From: Andrew Wood
Sent: 10 July 2017 16:29
To: Planning.Responses
Subject: FW: FG/198/16 - Plans

From: Ed Miller [REDACTED]
Sent: 03 July 2017 16:04
To: Andrew Wood
Cc: sally henderson; Craig Savage; Roger Elkins; Carole Robertson
Subject: FG/198/16 - Plans

GROUND FLOOR PLAN

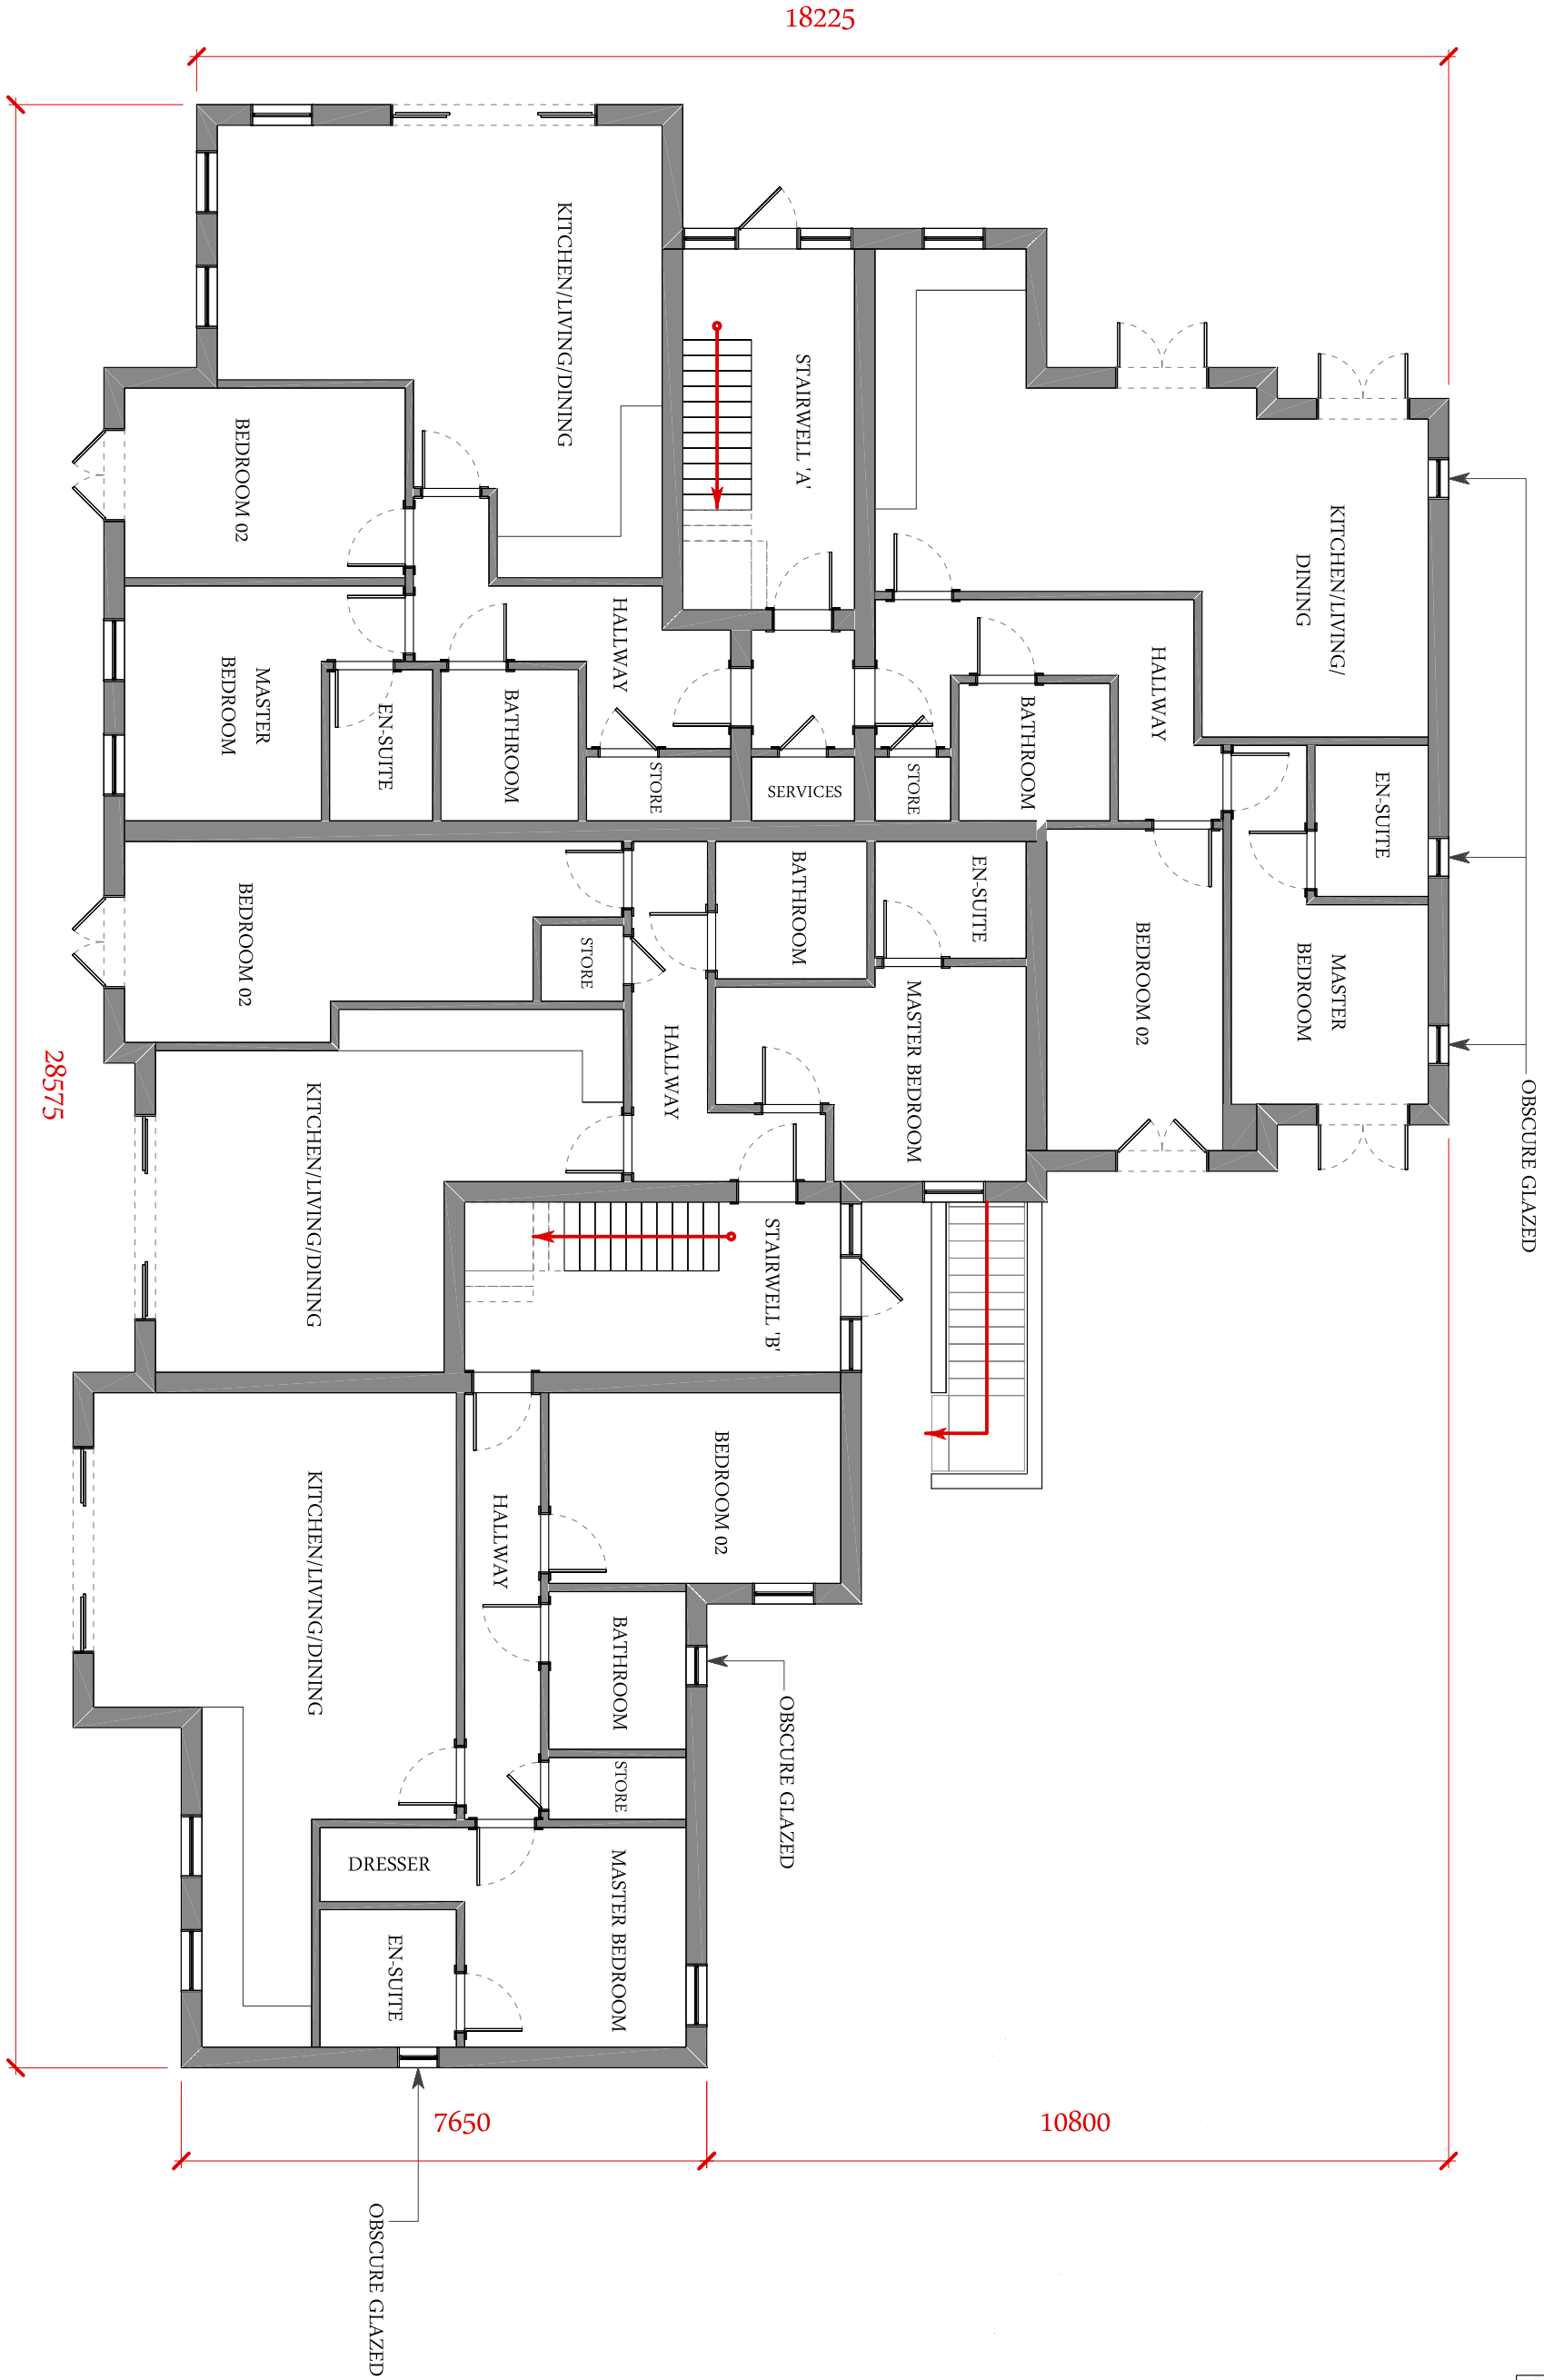
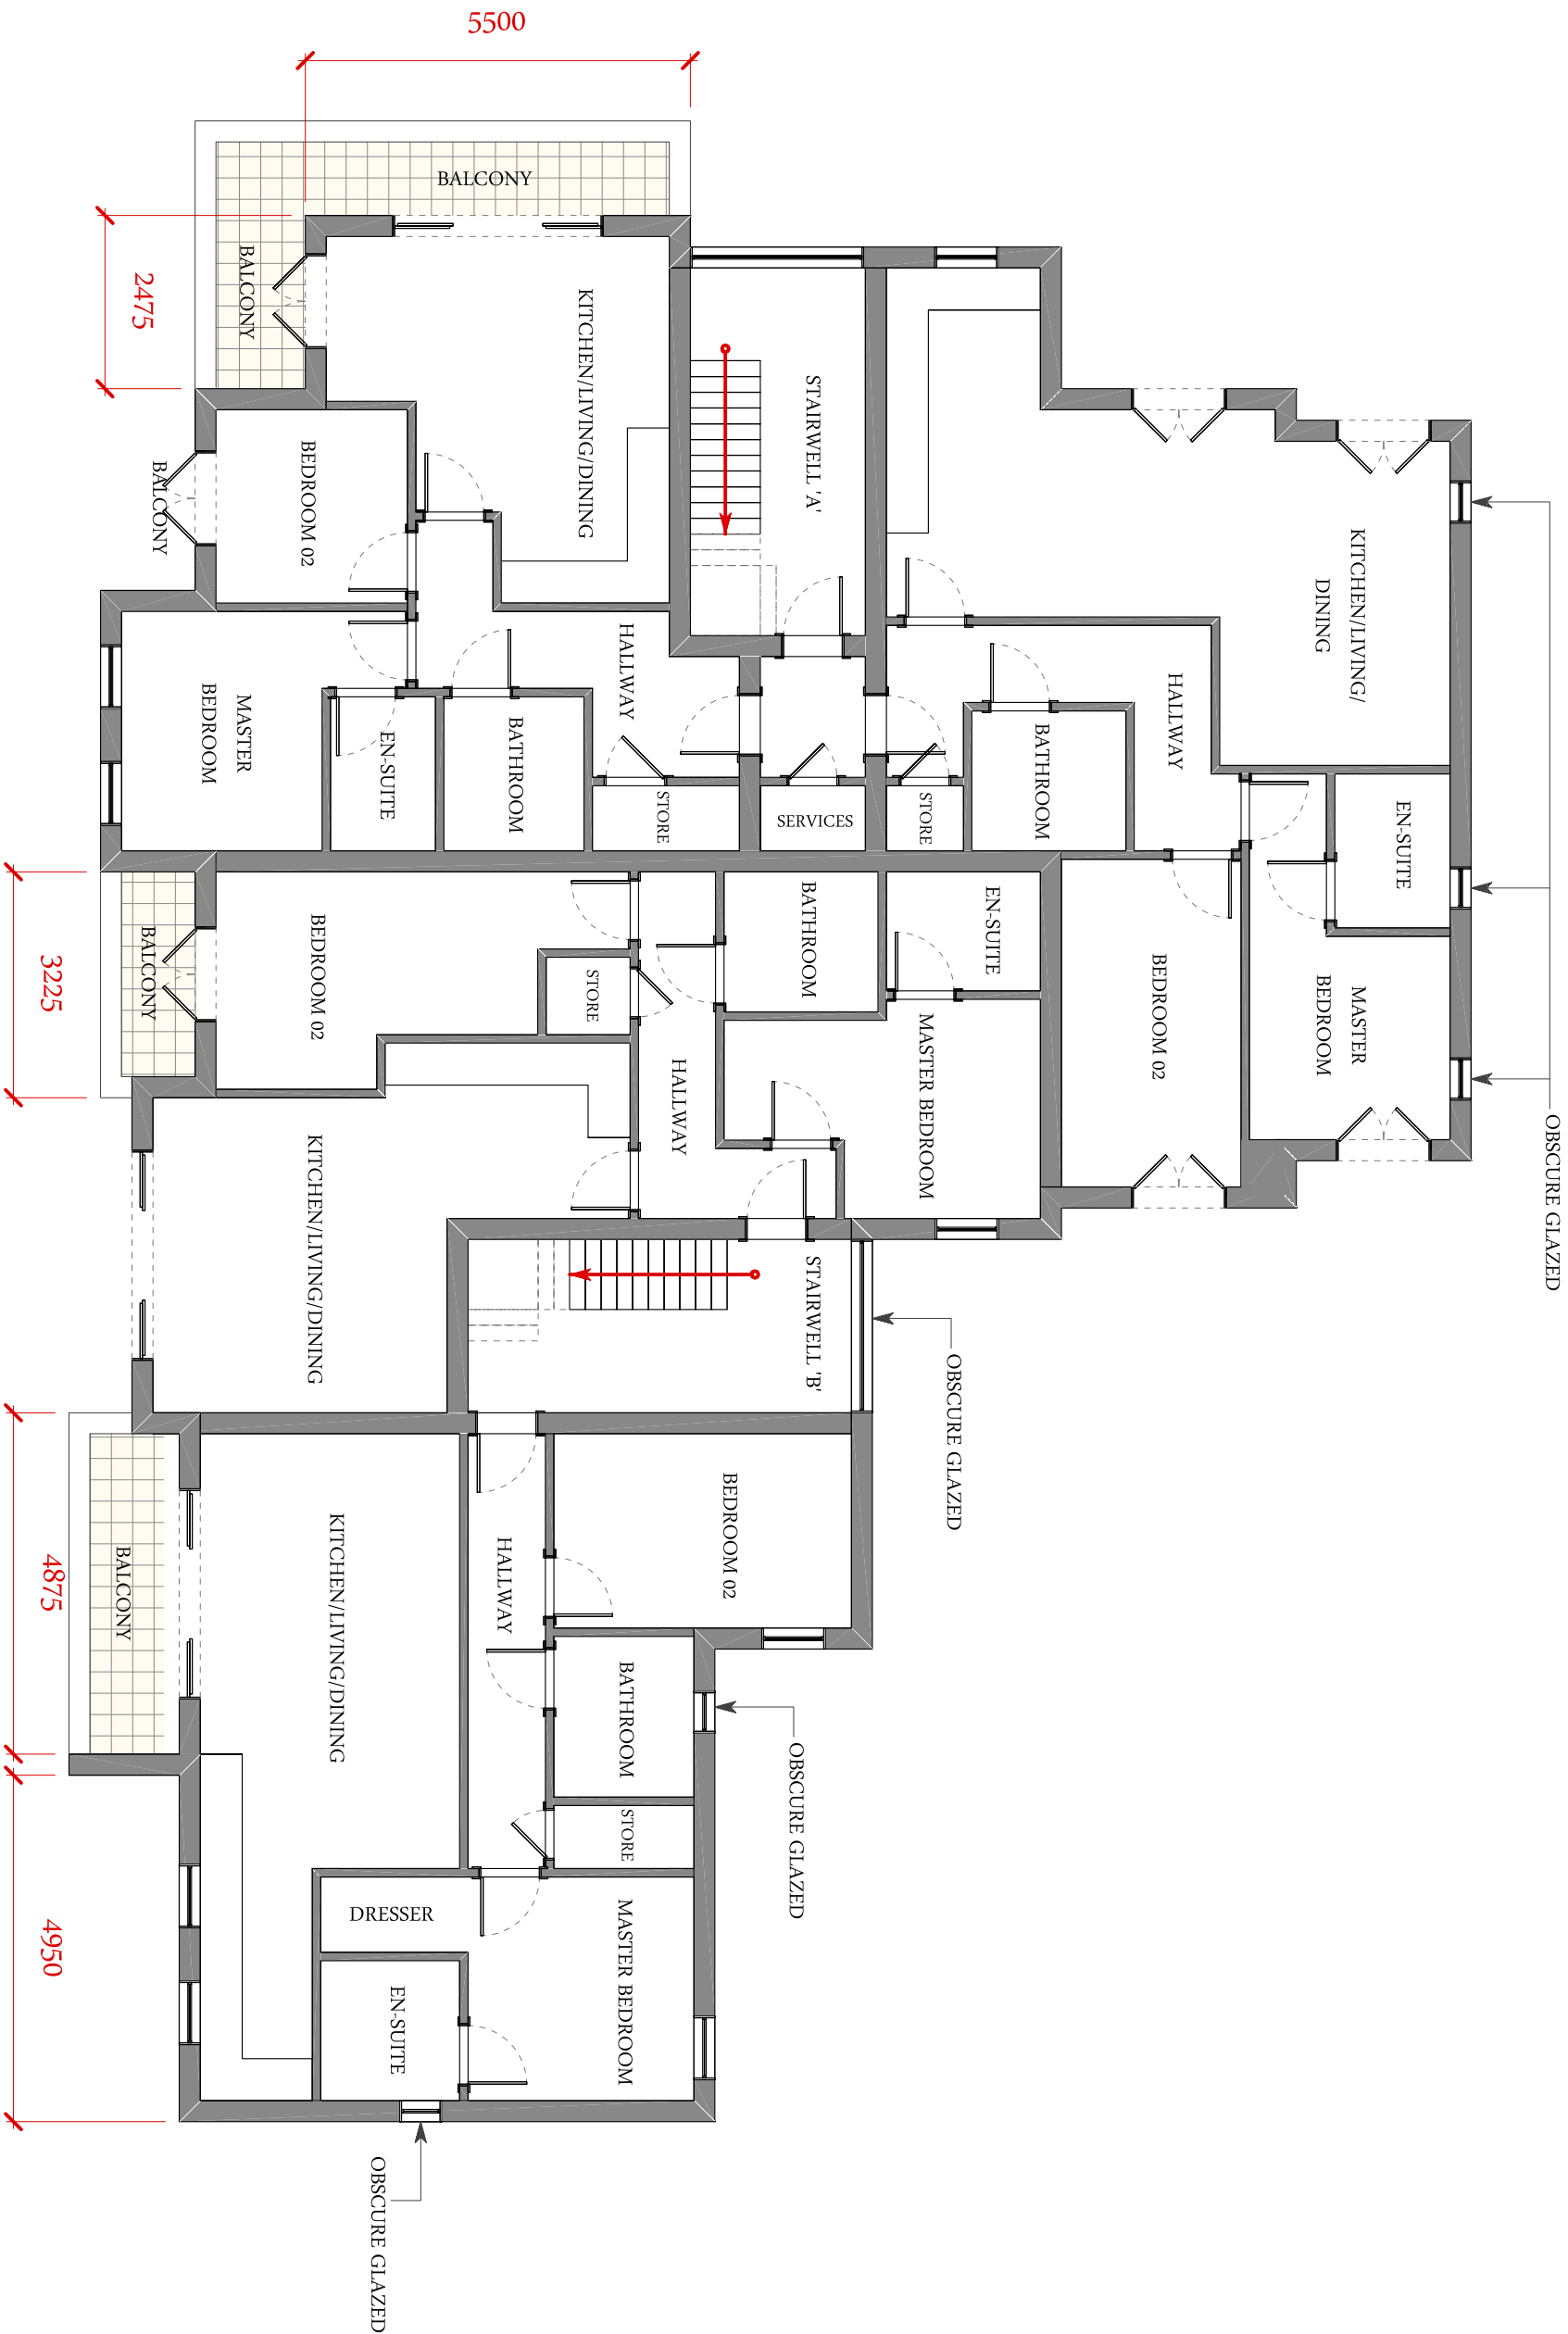
Mr Wood: Neither the latest Ground floor Plans nor the Street Scene, Sea Drive, both recently submitted, show any parking places fronting onto Sea Drive. But the covering minute from the architects, covering the revised plans (posted 29 June) refers to 12 parking places in all. The plan for the underground car park shows spaces numbered 3 to 12: are spaces 1 and 2 still intended to be on the ground floor, fronting Sea Drive? If so, why are they not shown on the latest plan and street scene? Isn't the absence of these prominent features very misleading for Members of the Development Control Committee when they come to consider the application. Or is there something I have misunderstood?- Ed Miller (Secretary, Ferring Conservation group)
